Application Reference: 2026/0610

Site Address: 11A School Street, Great Houghton, Barnsley, S70 0AE

Introduction: This application seeks full planning permission for the Install of front boundary wall and gates to dwelling (Amended Postcode)

11a SCHOOL STREET BOUNDARY WALL AND GATES

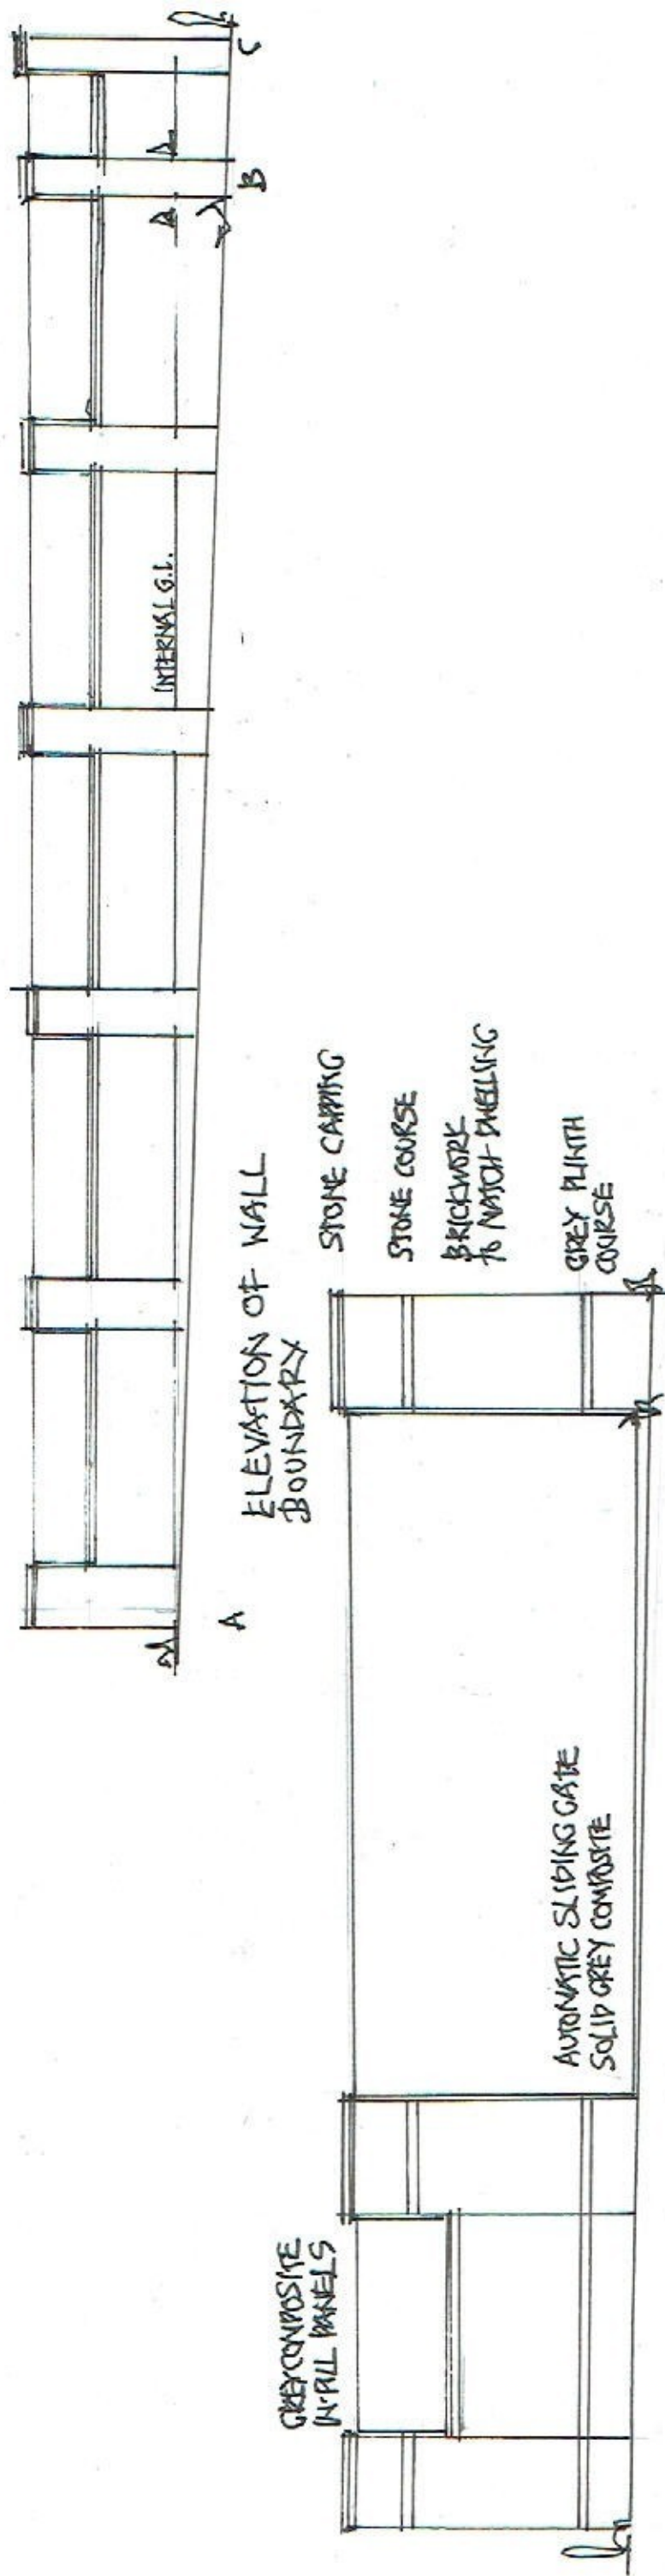
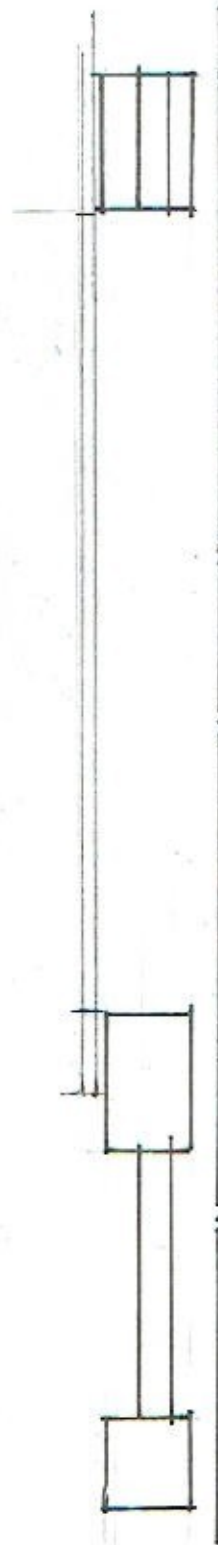
Whilst the design of the proposed brick wall does match with the new dwelling, using matching brickwork across the wall and pillars unfortunately the scale of the wall is simply too high. Even without the requirement for compliance with conditions 4, 8 and 9 of the original planning application 2020 /0750, as detailed below, the wall as it stood at the time of the site visit, without the proposed grey composite gates or wall panels in place, it is already too high and considerably out of character with the street scene.

No definitive height for the brick wall or the pillars have been provided, based upon measurements from the submitted plan at a scale of 1:50, indicative measurements would be between approximately 2.2m and 2.5 high, due to ground level difference, pillars, and potentially for the whole wall once the proposed grey panels have been installed, and 2.2m for the gate. From visual sight of the wall in person during a site visit, the proposed wall is clearly substantially higher than the 1m height required by condition 9 of the decision notice 2020/0750. In consultation from Highways DC regarding this application, they have reinstated their request for compliance with conditions 8 and 9 of decision notice 2020/0750. This includes the wall being reduced to the specified 1m height outlined with the original decision notice, and that the required visibility splays required by condition 8 of the same decision notice are also implemented.

In addition to the clearly obvious height of the wall being much higher than 1m, photographs taken on the site visit have been compared to the Google Street View image from June 2025. With a metal telegraph pole providing a reference point. From these images it is clear to see that height of the wall is slightly higher than the previous stone wall, whilst being undeniably clear that the stone

pillars of the wall reach to a significantly higher level than the current wall or previous stone wall. As the wall is currently incomplete, with the potential for grey composite panel infills to be installed between the pillars, the total height of the wall itself may reach the height of the currently installed pillars.

In relation to the dwelling, despite the matching design of the currently erected wall, before the addition of gates or the composite panels, as already noted, the height would not be of an appropriate scale to the new dwelling. Once the wall has been completed, with or without the grey composite panels, and the gates have been installed, the proposal would significantly impact upon the scale, design and character of the dwellinghouse, through likeness to a secure compound rather than residential dwelling. This impact is further escalated by the current but equally unapproved high side boundary treatments, and significantly through the height and length of the boundary treatment, with a frontage adjacent to the highway of approximately 34m.

In conclusion, and without consideration of condition 4 of the planning decision notice 2026/0750, at the most basic level, the wall is simply too high, and would if completed to the specification of the supplied plans, would not harmonise with the dwellinghouse. Furthermore, the proposal would be considerably out of character, and due to its approximate 34m length along the road and approximate height of up to 2.5m, would create an intrusive and out of character addition to the street scene, which would have a considerable negative impact.

Whilst highways have not formally objected to the proposal, they did request that condition numbers 8 and 9 from planning decision notice 2020/0750, are implemented, with a final consultation decision deferred until corrective information is provided. This request was relayed to the applicants via their agent, but no response has been received about this request. Without sufficient information being provided to ascertain the impact upon highway safety, but a visual review of the proposal indicating that the proposal, as it currently stands does not meet condition 9; the proposal falls below the requested standards, resulting in a potential risk to highway safety.

Highways DC through consultation has requested that the wall and gates are constructed to meet correct height, and include the visibility splays required to comply with conditions 8 and 9 of the original decision notice 2026/0750. As the wall is already partially constructed, this would require the wall to be retrospectively adjusted to meet those requirements

- Concerns over the height and design of the wall, along with potential concern over further boundary treatments at the site was raised with the applicant. Also highlighted was the fact that Highways DC had raised concern that the proposals would not meet the required visibility splays of condition 8 of planning application 2020/0750 or the maximum 1m height for boundary treatments above the level of the nearside channel line of the public highway, in accordance with condition 9 of planning application 202/0750, and requested to be complied with in this application.
